Addendum No. 1

RE: Contract # C204149

Halifax County (R-3822, U-5725)

NC-125 From I-95 To Old Farm Road South; SR-1627 (Three Bridge Road)

REVISIONS

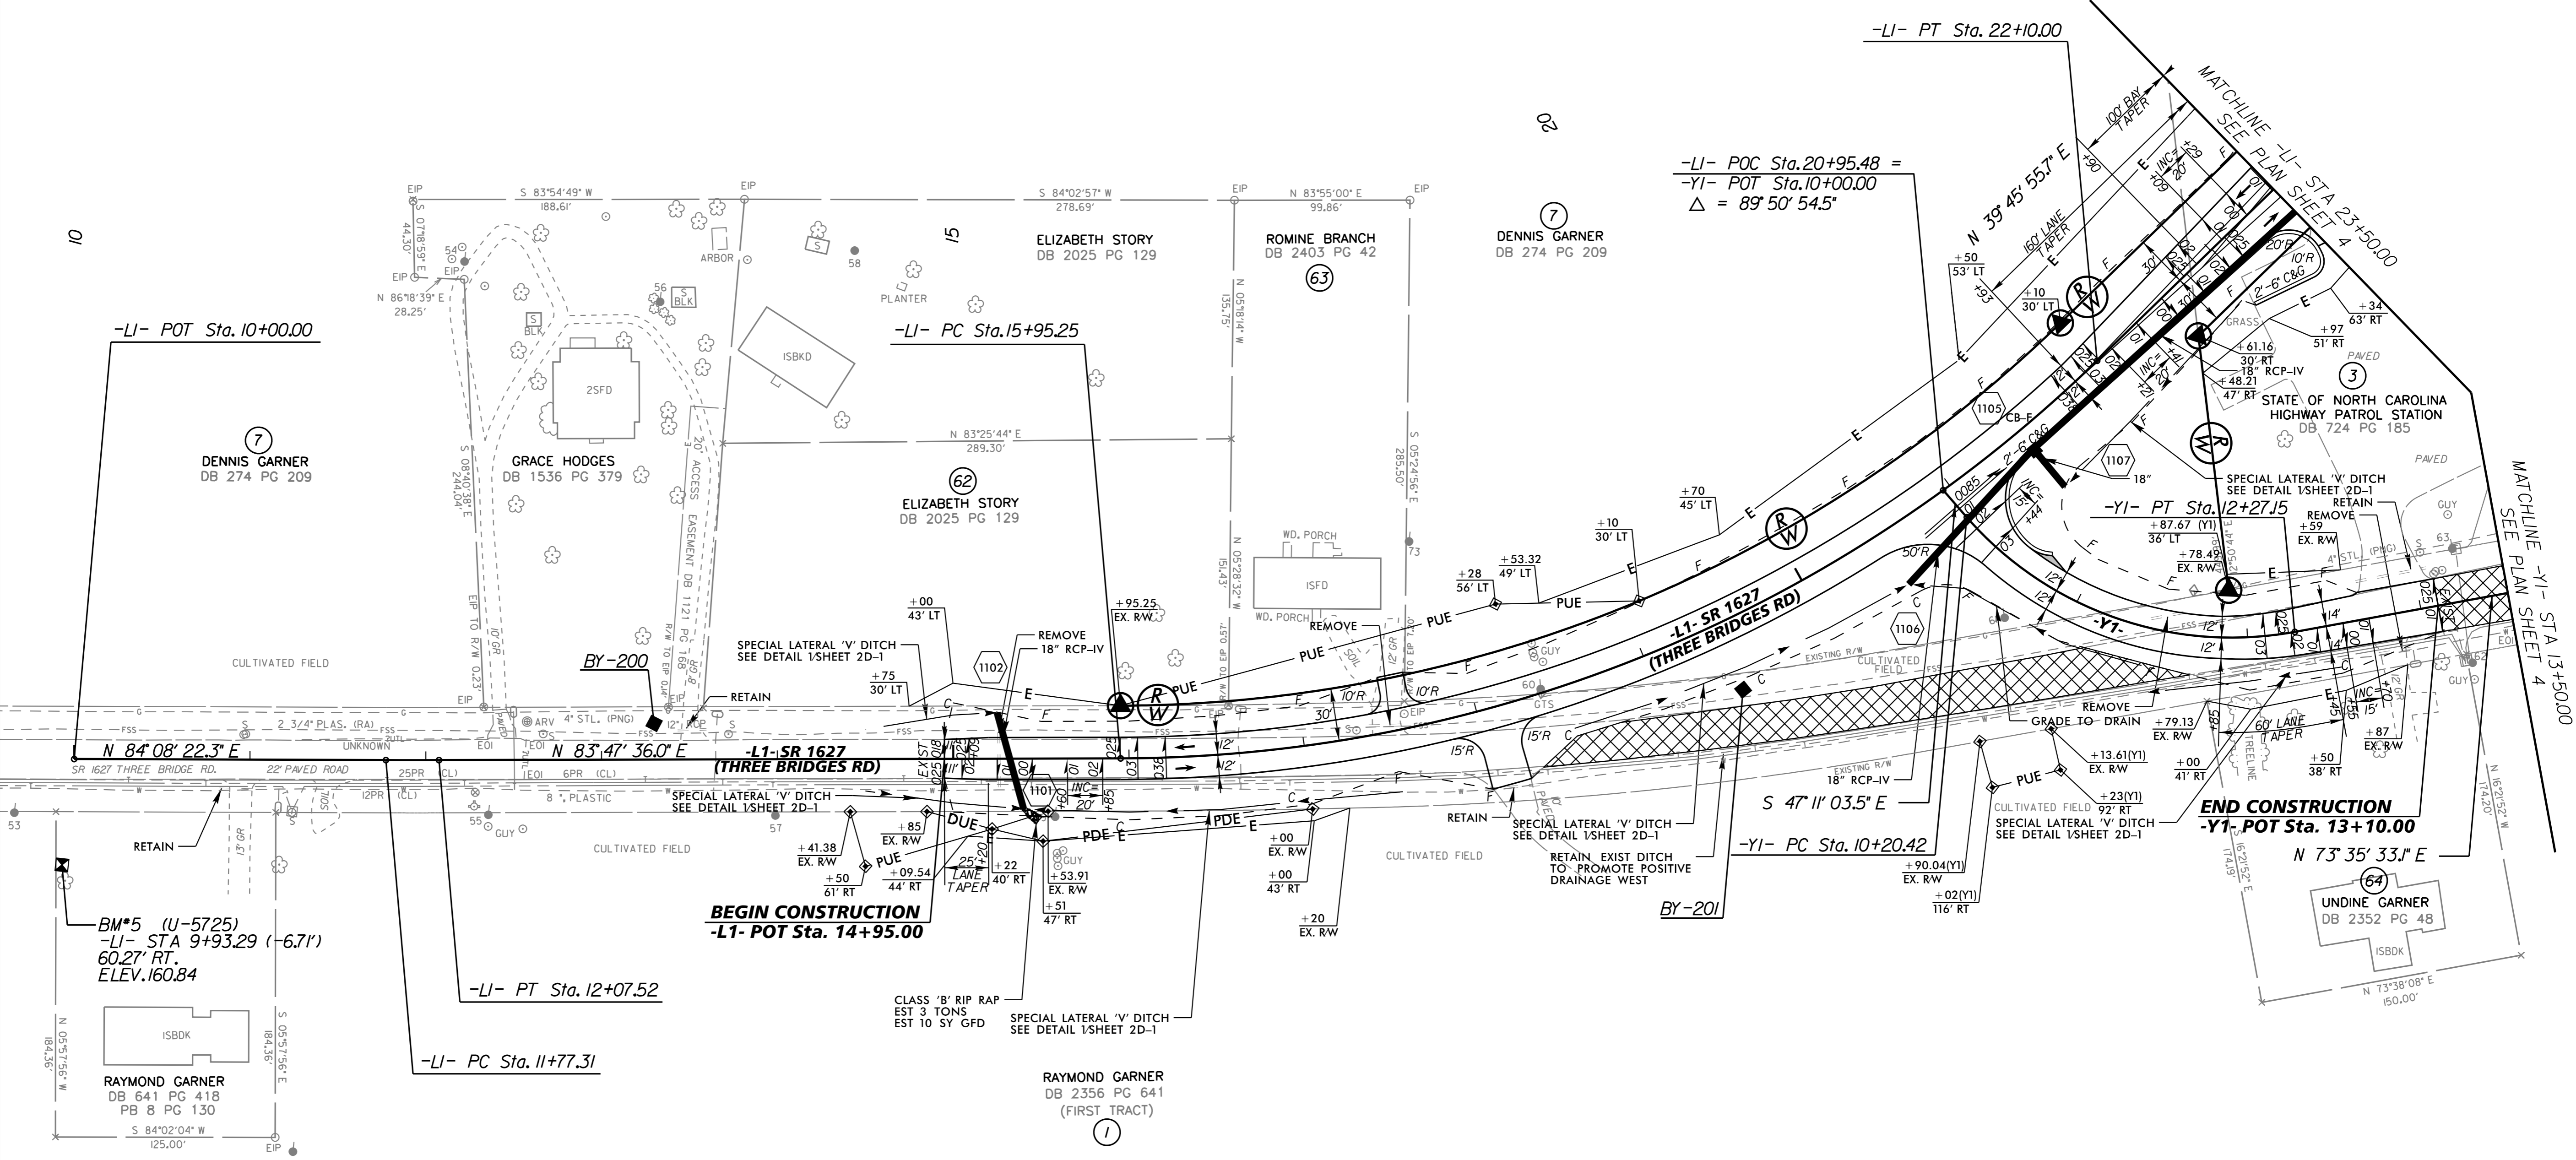
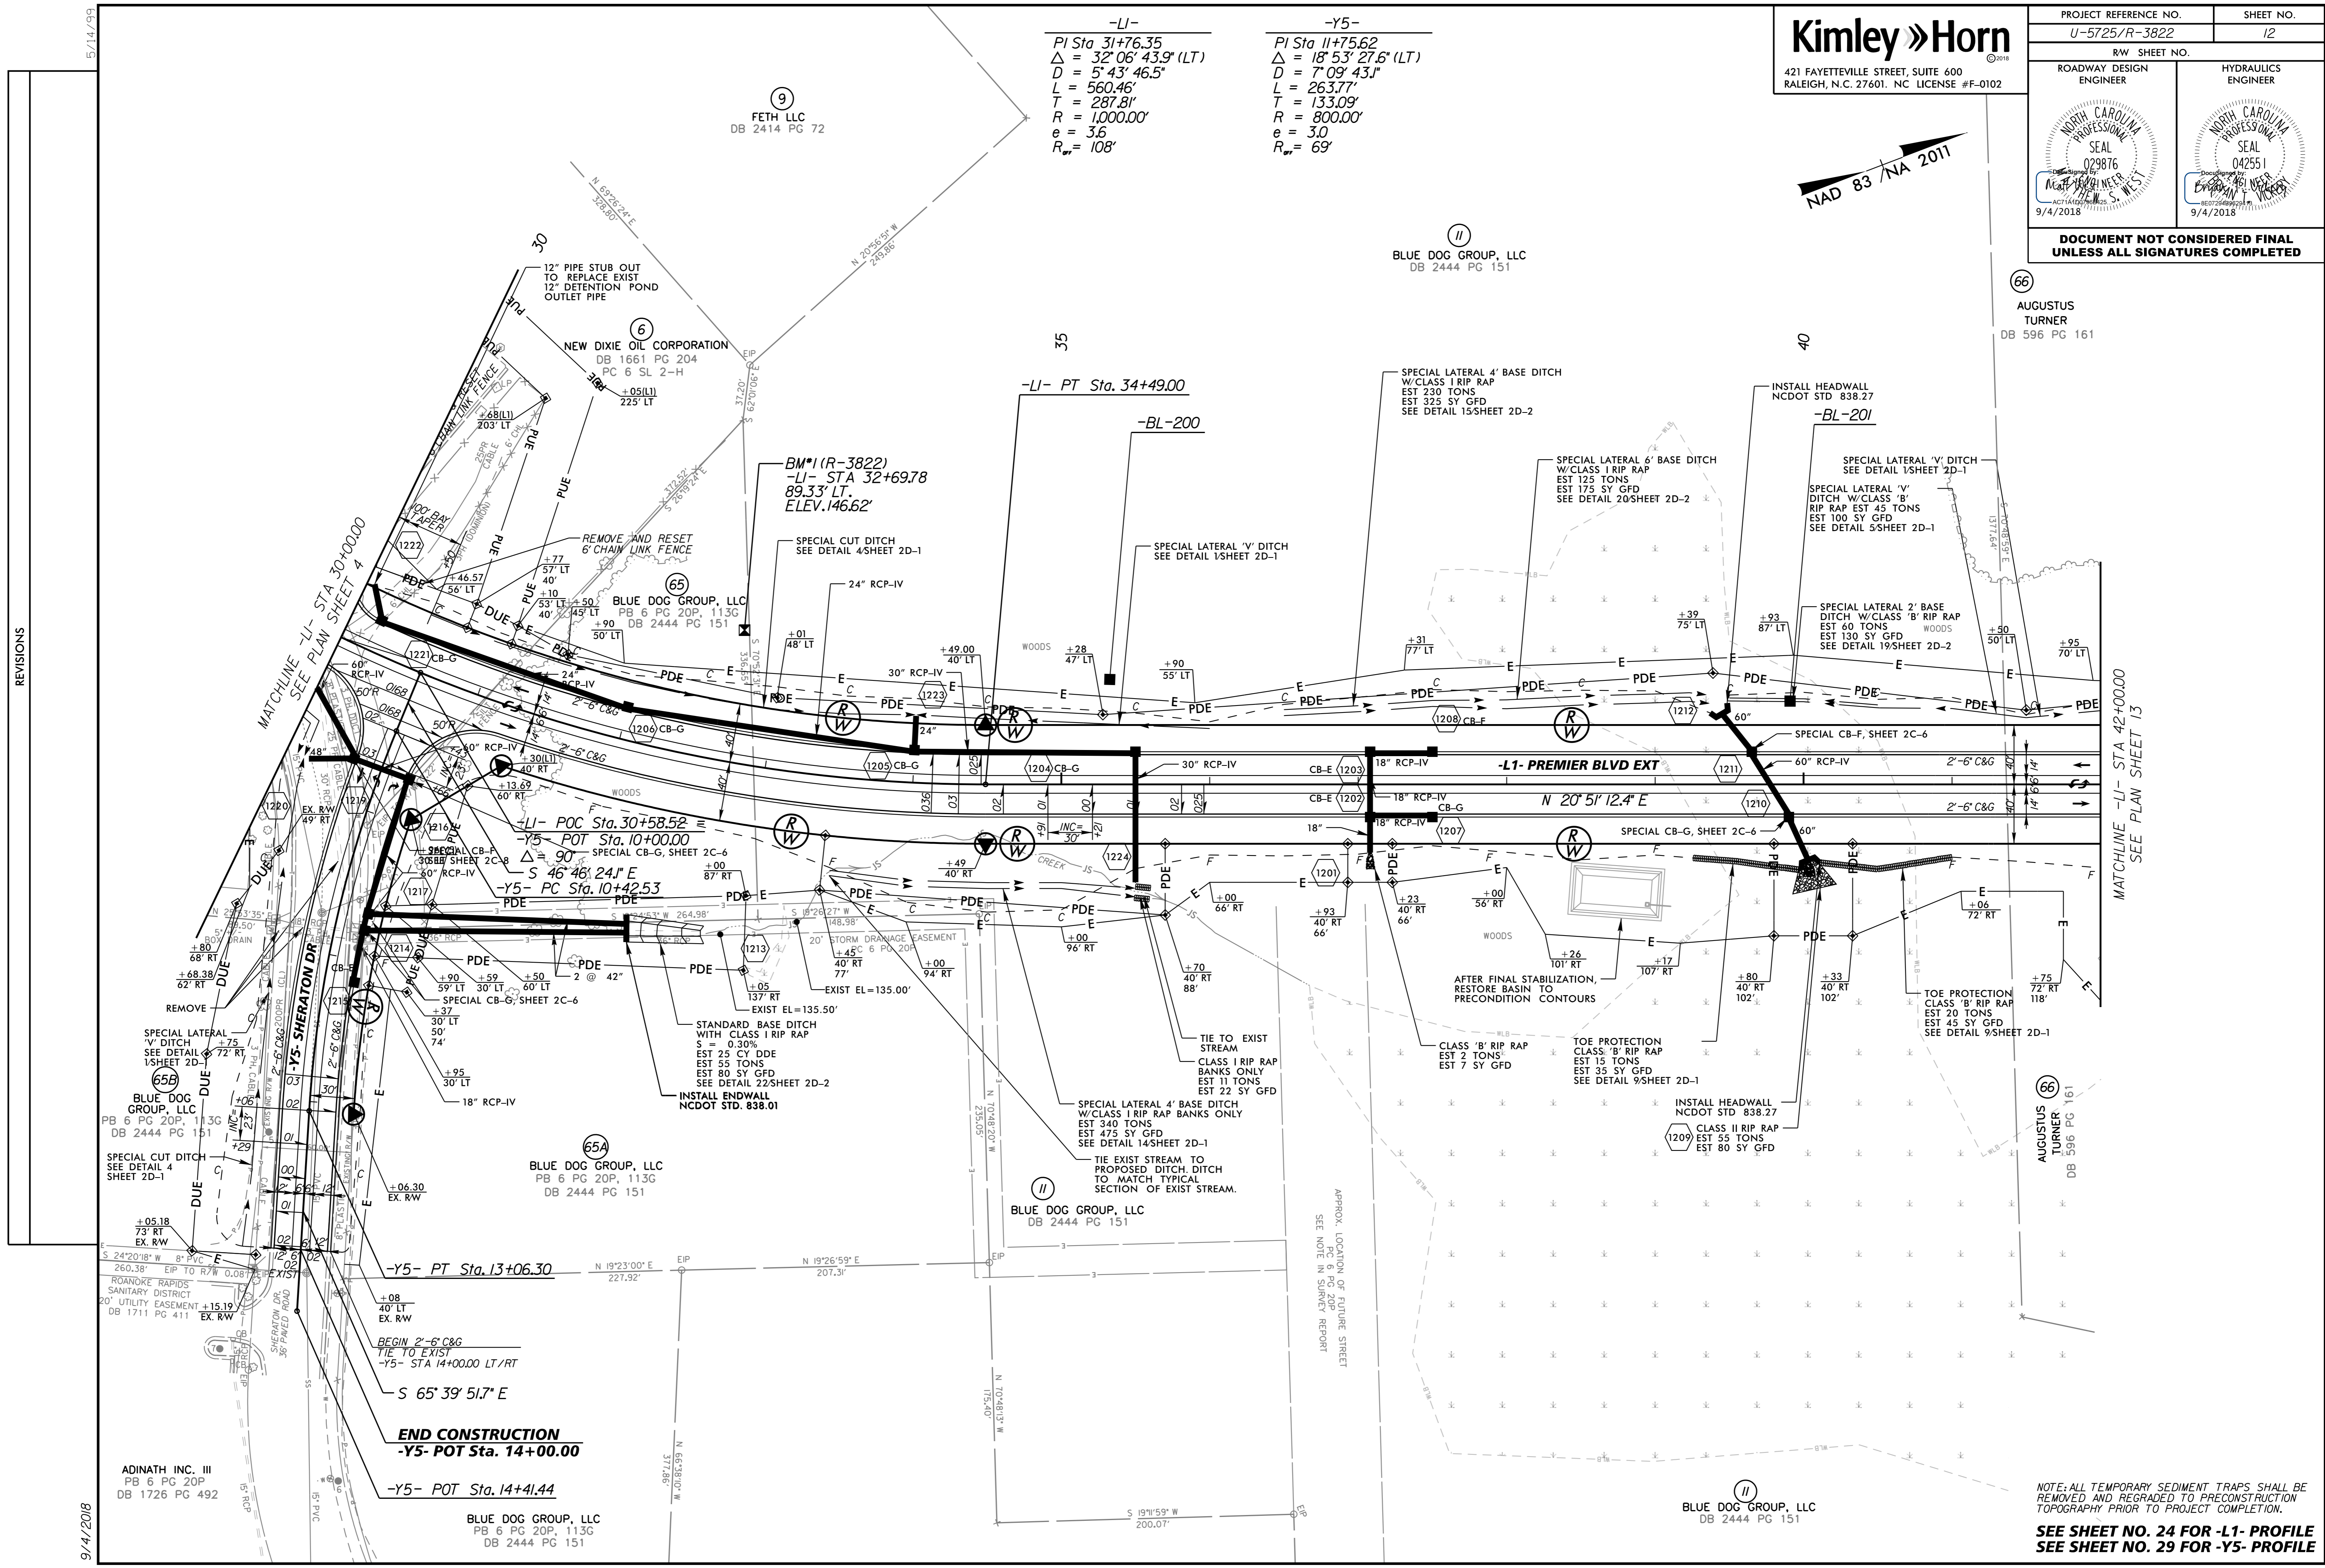
Sheet No.	Revisions
4 thru 19	Revised Right of Way and Easement notes for some callouts. Right of Way and easement lines have not changed
